**Holiday Inn Express Hotel Bicester Gateway
Business Park Wendlebury Road Chesterton
OX25 2BX**

19/00248/DISC

Proposal: Discharge conditions 2, 4 and 12 17/02557/REM

CLIENT
 London & Regional
 PROJECT TITLE
 Bicester Gateway, Hotel
 DRAWING TITLE
 Trees to be Removed / Retained
 DRAWING STATUS
 For Information

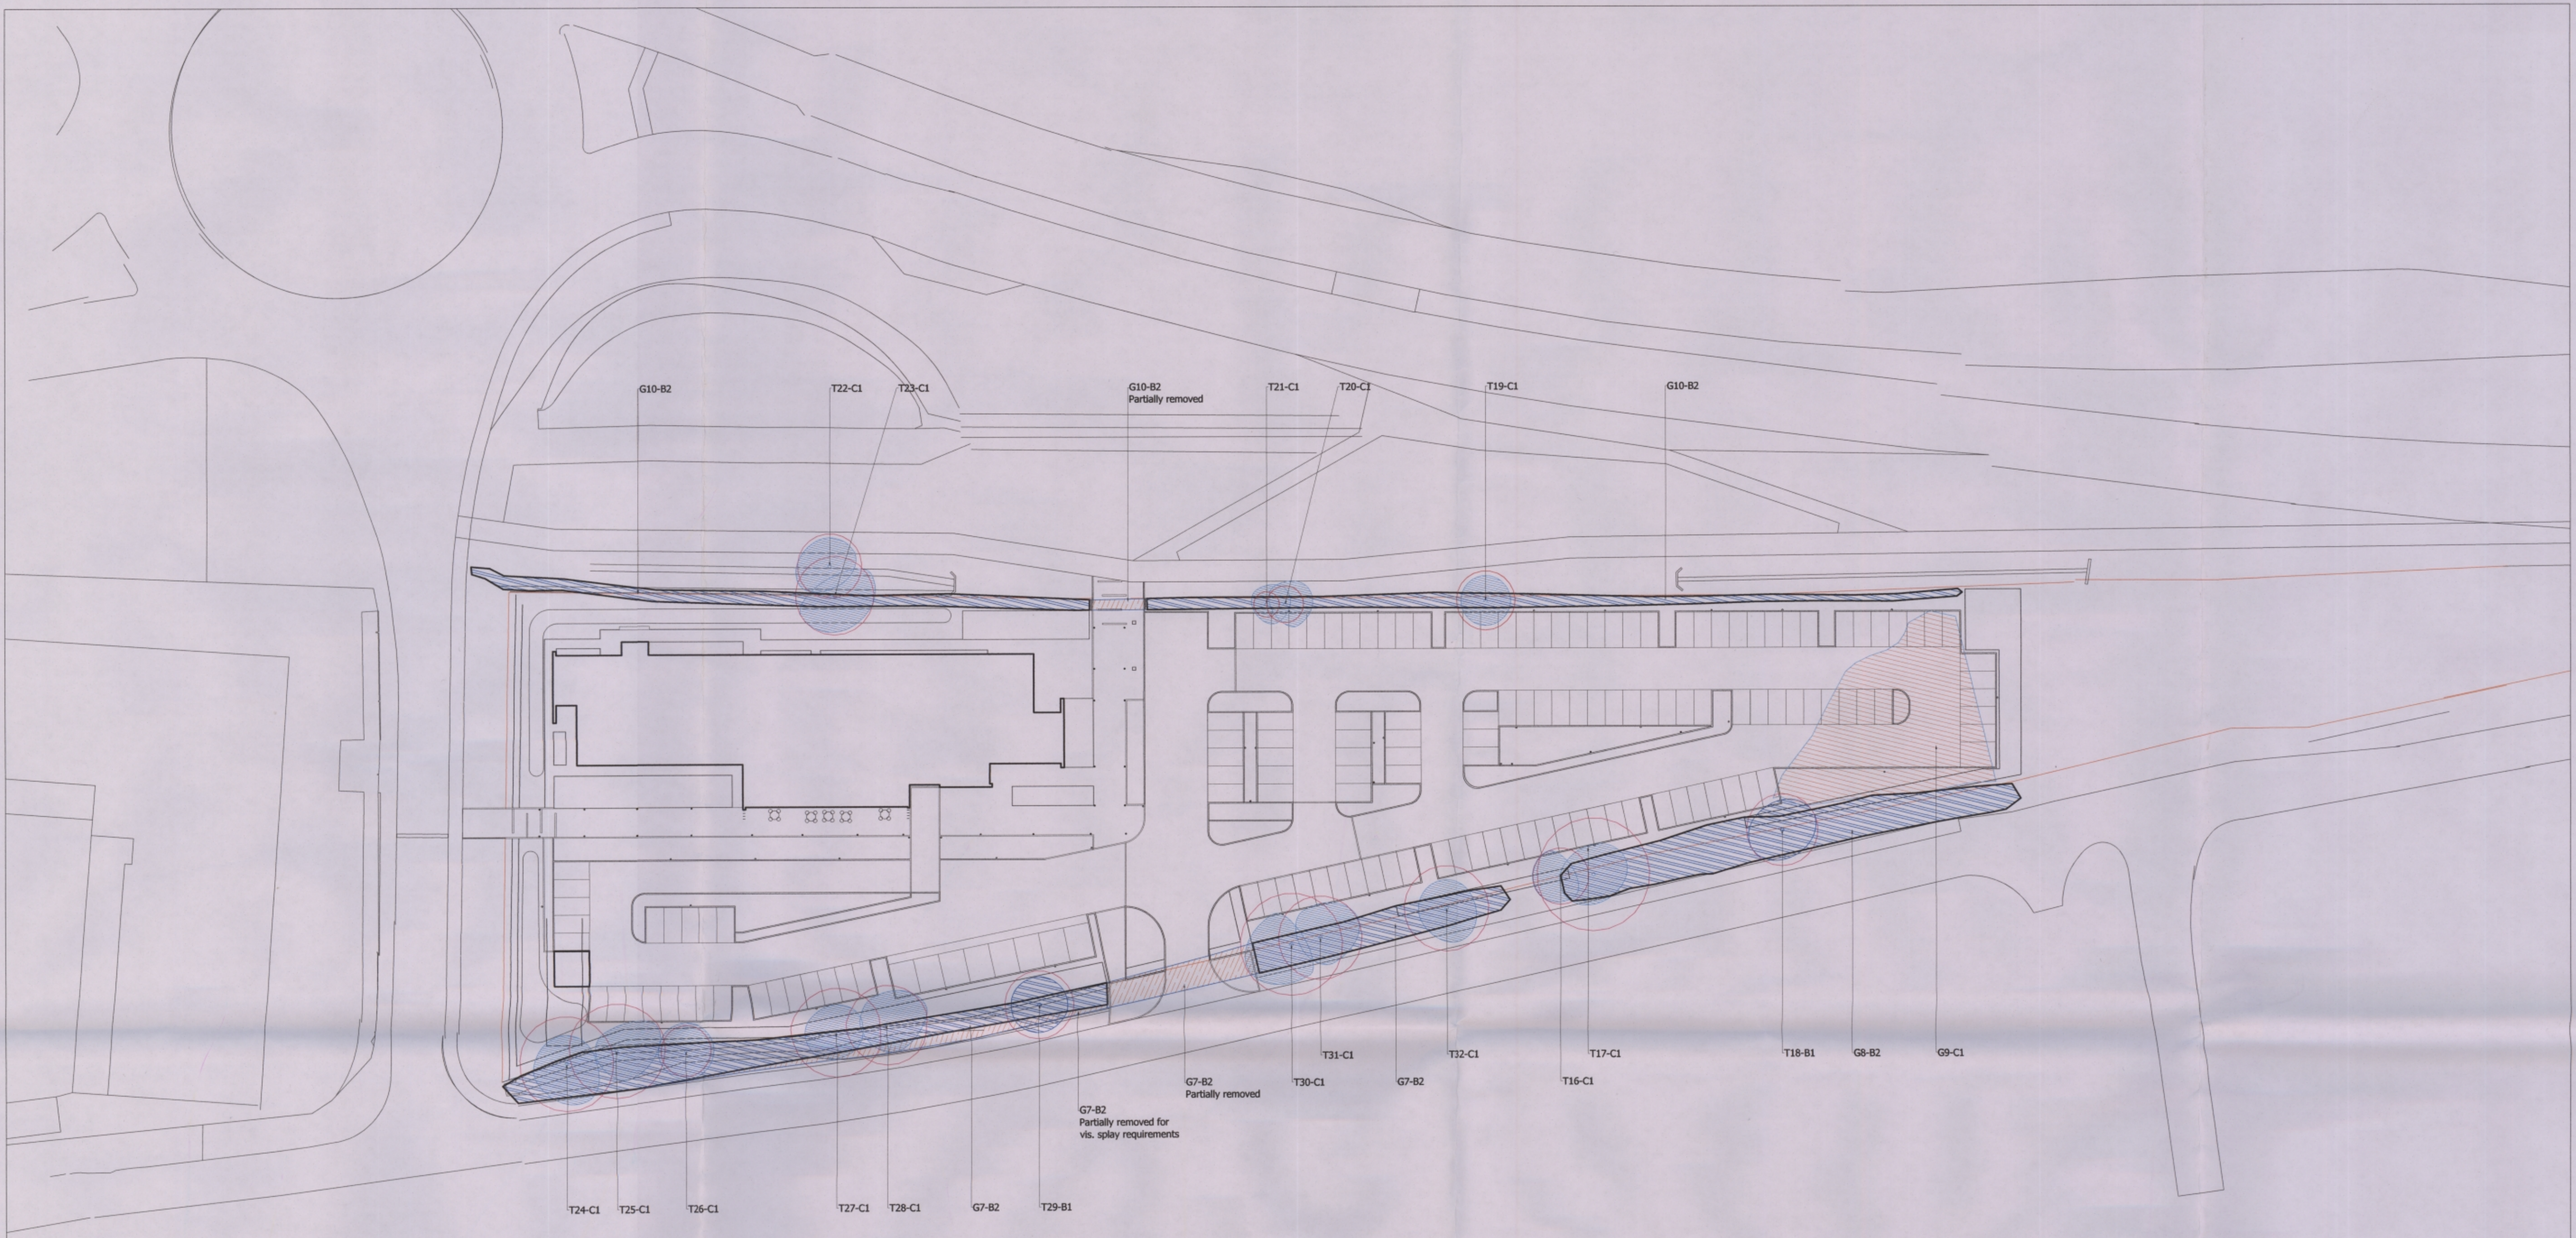
- 4.1 CDC ARBORICULTURE: No objections with reference to the tree/ hedge management and the proposal seeks to retain the majority of boundary trees removing only one group. No concerns for retained trees providing protective measures as detailed within the landscape management plans and previous AMS are followed. Has a detailed planting plan been submitted with detail on trees, species and tree pit details?

Officer response – landscape plans have been approved and the plan provides some wording on tree pits. However no plan to show tree pits appears to have been approved and there is no planning condition seeking this further detail.
